# Rezoning Transportation Analysis

Petition Number: 2019-128

## Revision Log:

Date	Description
10-21-2019	First Review
06-26-2020	Second Review

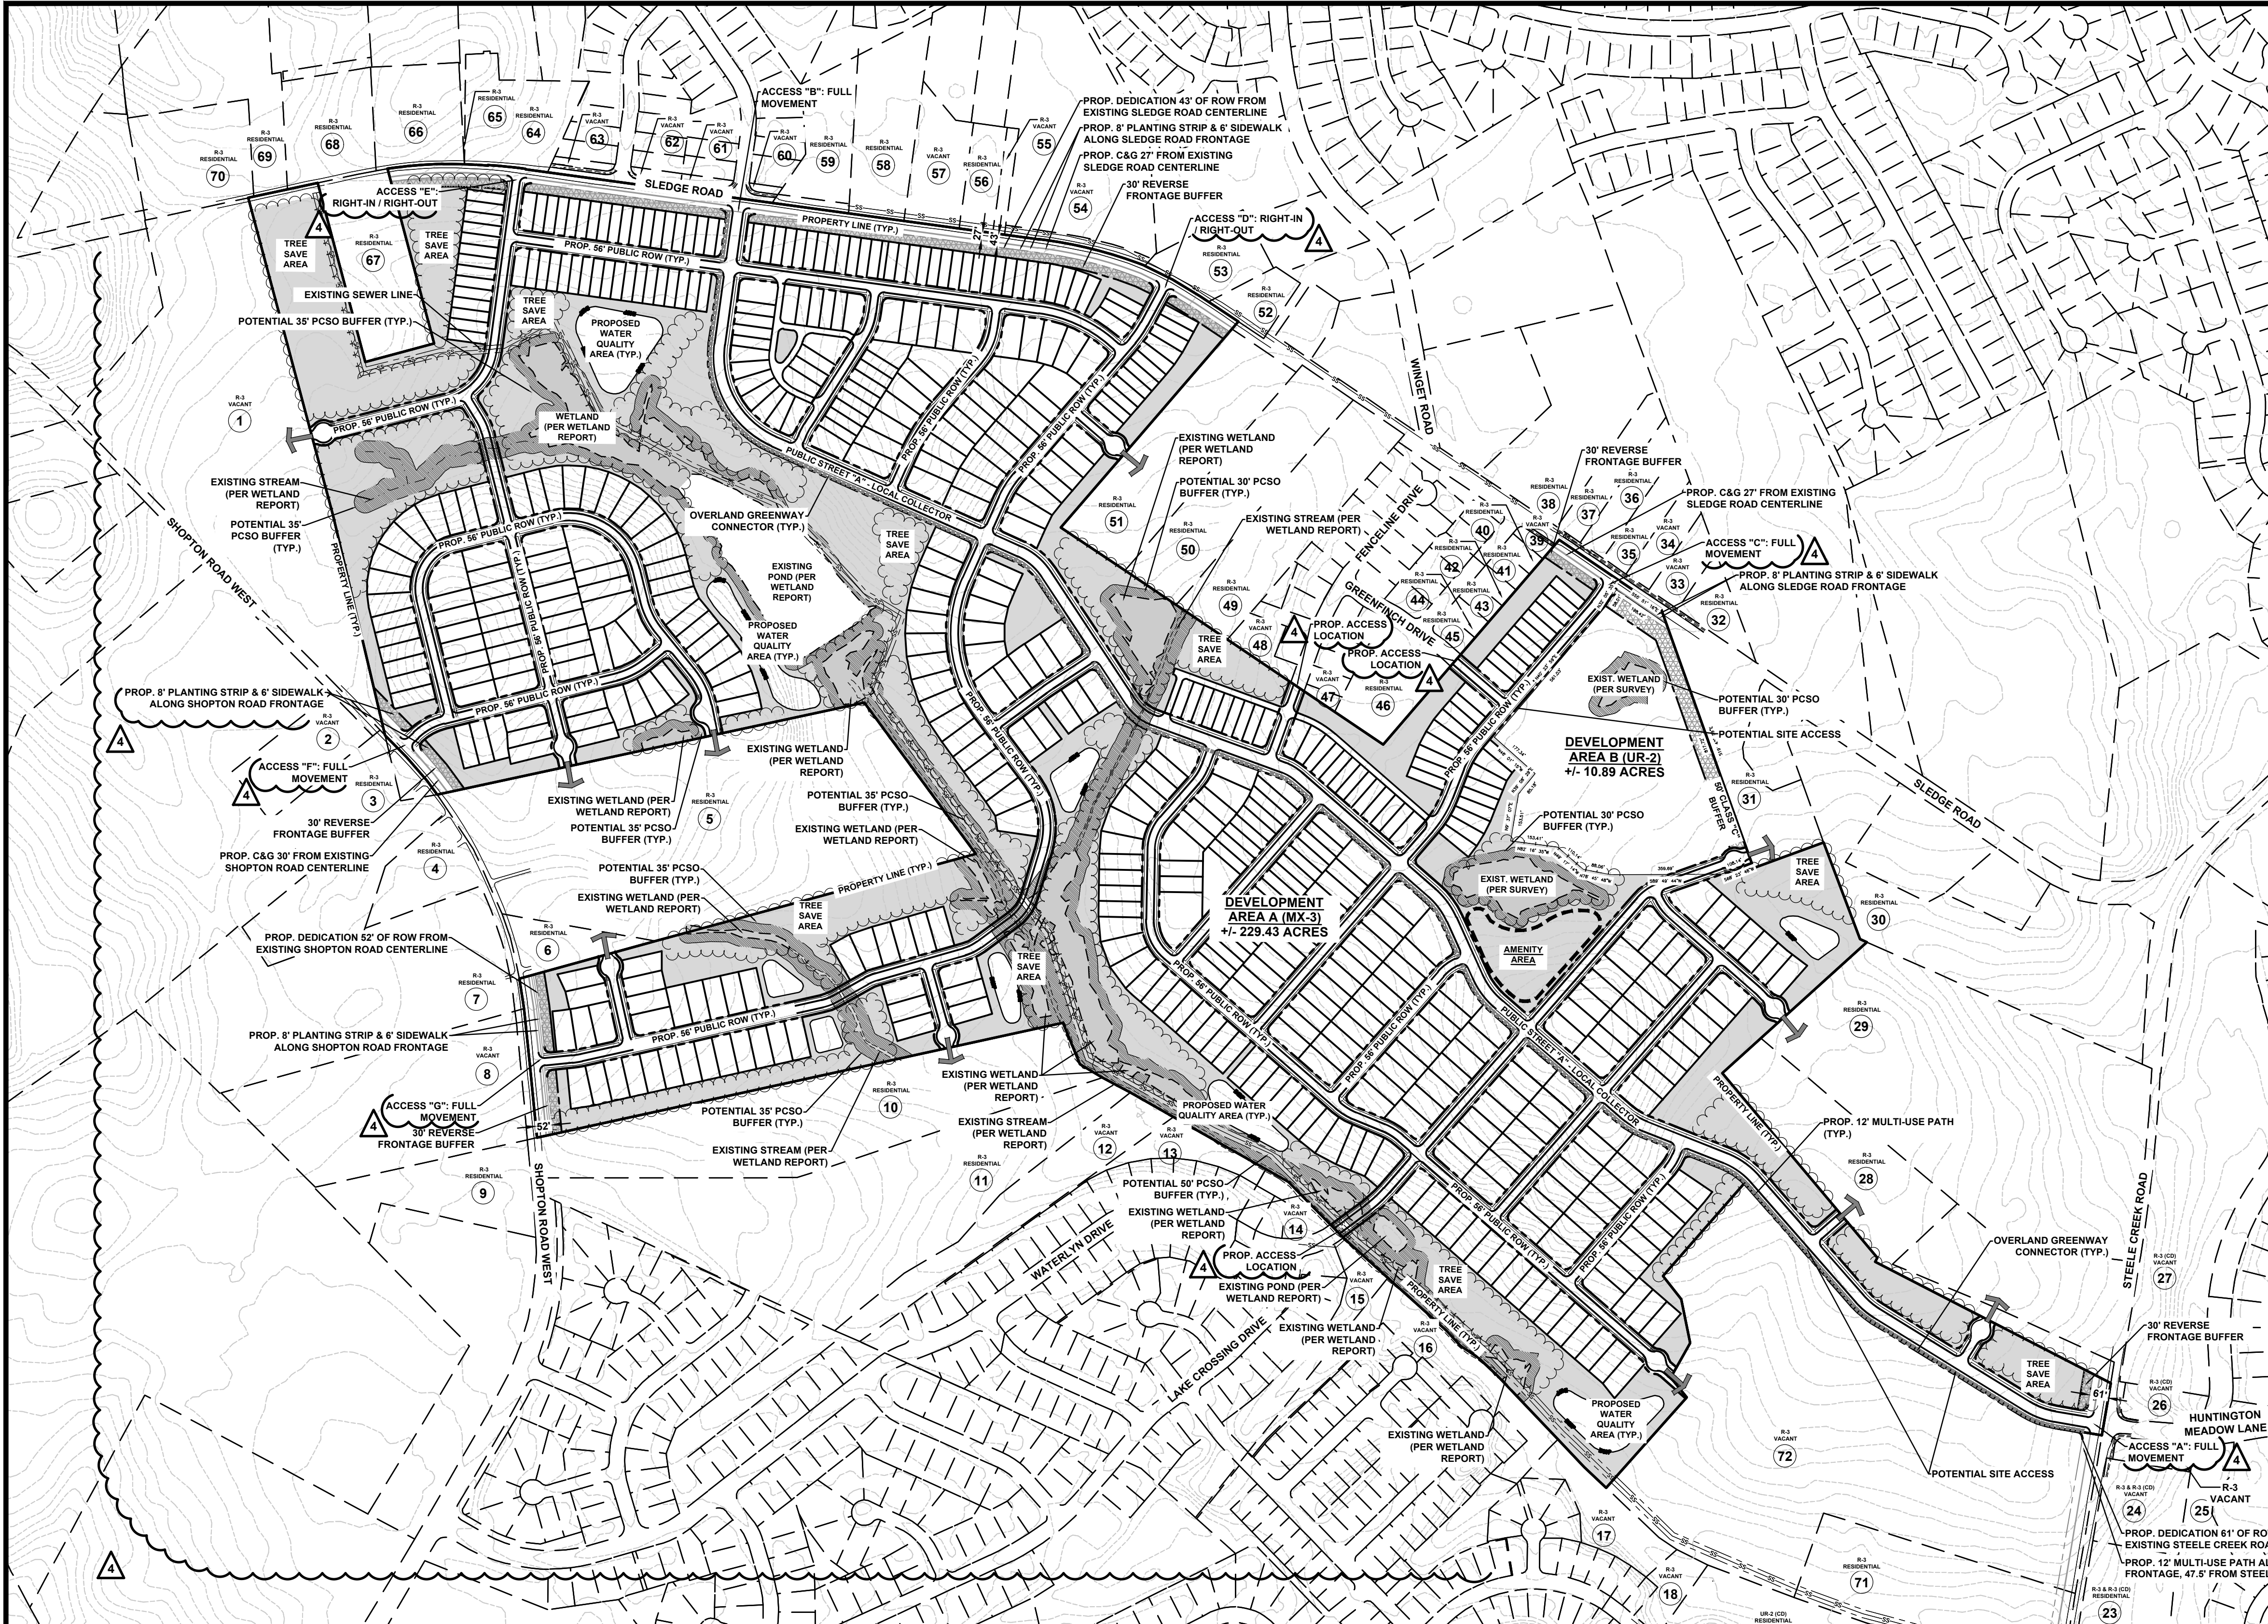
- b. **Sledge Road:** Location of curb and gutter should be moved to 27 feet from existing centerline, to accommodate for the Comprehensive Transportation Plan's recommended thoroughfare improvements for a future 2-way divided buffered bike lane cross section. The site plan should show the curb and gutter labeled and dimensioned from the centerline for each road.

- c. **Shopton Road:** Location of curb and gutter should be moved to 30 feet from existing centerline, to accommodate for the Comprehensive Transportation Plan's recommended thoroughfare improvements for a future 4-way divided (USDG Avenue) roadway section.

3. The petitioner should revise the site plan and conditional note(s) to commit to dedicate 43 feet of right-of-way from the existing Sledge Road centerline. The site plan should label and dimension the right-of-way from the road centerline.
4. The petitioner should revise the site plan and conditional note(s) to commit to construct an 8-foot planting strip and 6-foot sidewalk along the frontage of Sledge Road. The site plan should label and dimension both items from the back of curb and gutter and road centerline.

5. The petitioner should revise the site plan and conditional note(s) to commit to dedicate 52 feet of right-of-way from the existing Shopton Road centerline, for a future 4-lane divided roadway section that will accommodate an 8' planting strip and 12' multi-use path.
6. The petitioner should revise the site plan and conditional note(s) to commit to construct a 6-foot sidewalk along of the frontage of Shopton Road and to establish a connection to the existing sidewalk stub provided by the existing Waterlyn Subdivision. The site plan should label and dimension both items from the back of curb and gutter and road centerline.

7. The petitioner should revise the site plan and conditional note(s) to commit to dedicate 61 feet of right-of-way from the existing Steele Creek Road centerline, to account for an additional 2-feet from the back of the proposed multi-use path.

9. The petitioner should revise the site plan and conditional note(s) to commit to construct a 12-foot multi-use path along of the frontage of Steele Creek Road 47.5-feet from existing centerline. The site plan should label and dimension both items from the back of curb and gutter and road centerline.

Typical Street Sections & Land Development Standards  
Not to Scale

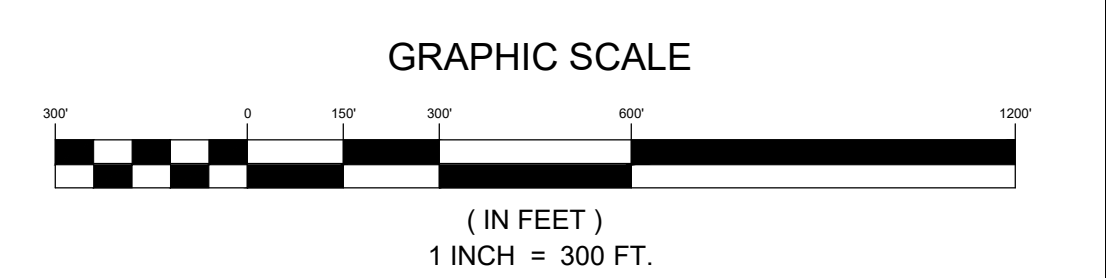
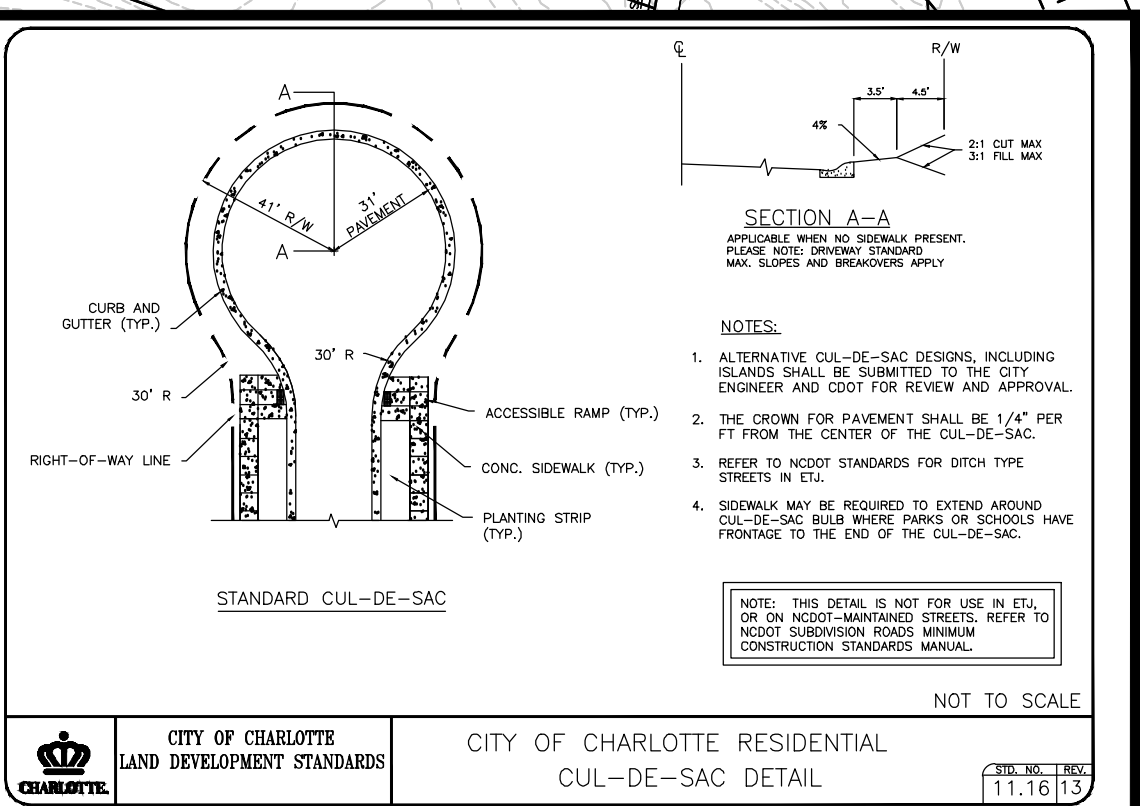
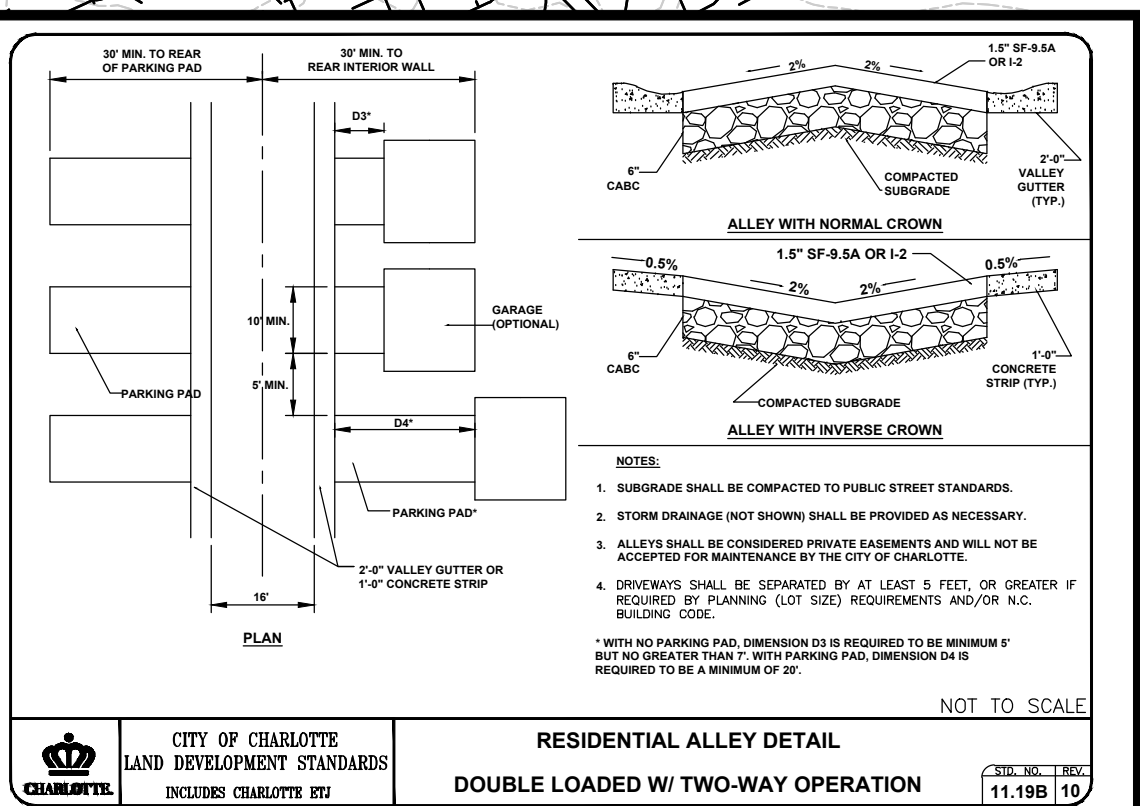
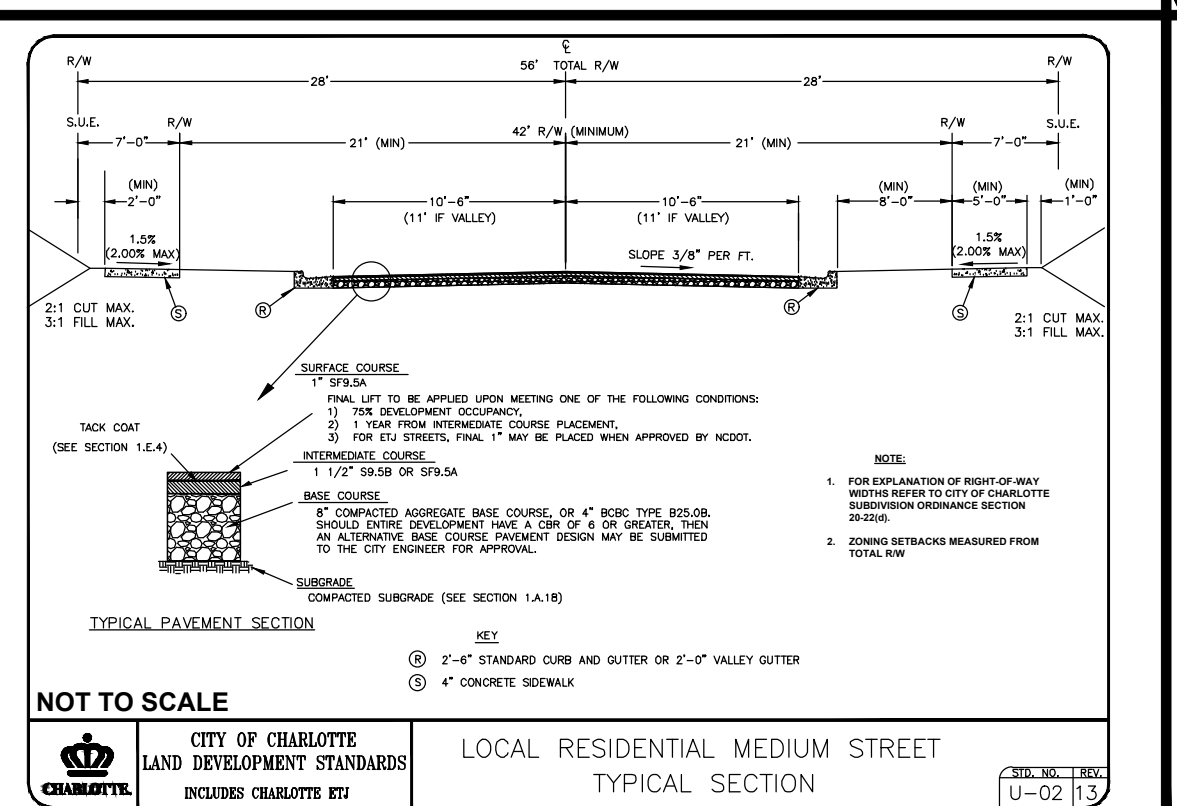
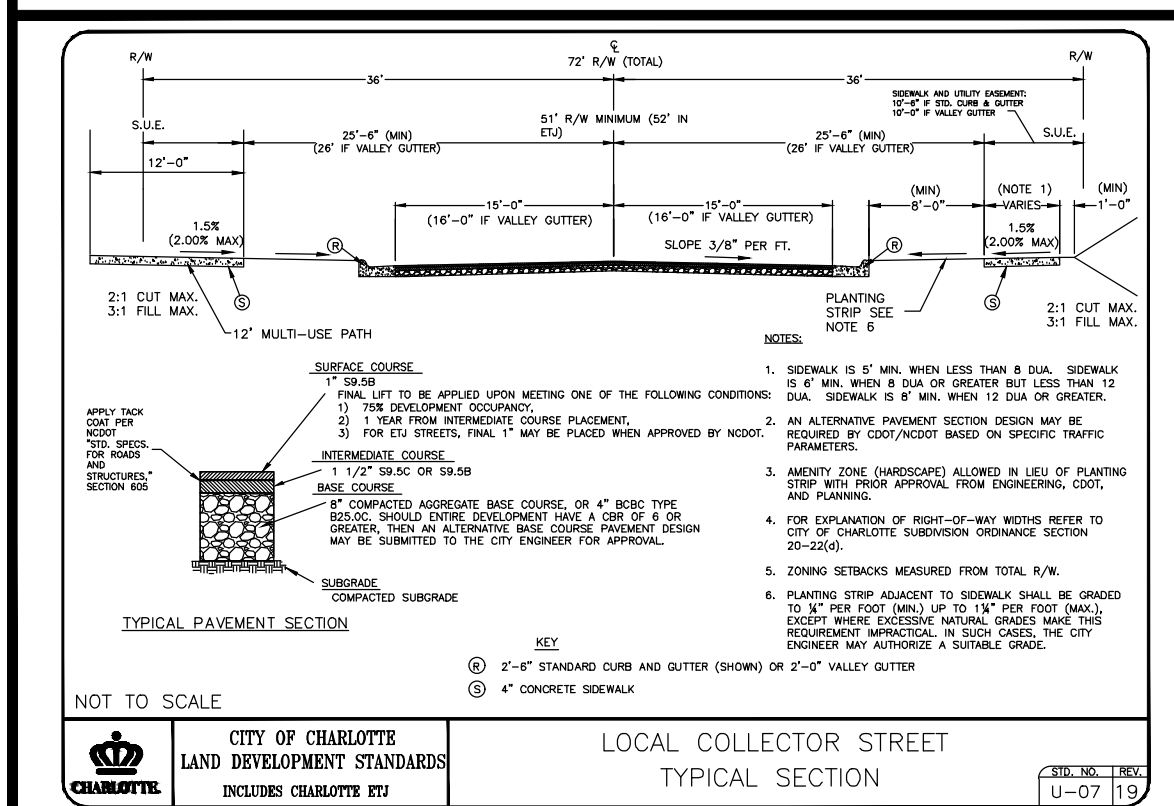
10. The petitioner should revise the site plan and conditional note(s) to specify each proposed street's USDG cross section.
11. The petitioner should revise the site plan and conditional note(s) to propose the recommended greenway alignment to the McDowell Nature Center and Preserve, per the Council-adopted Steele Creek Area Plan.
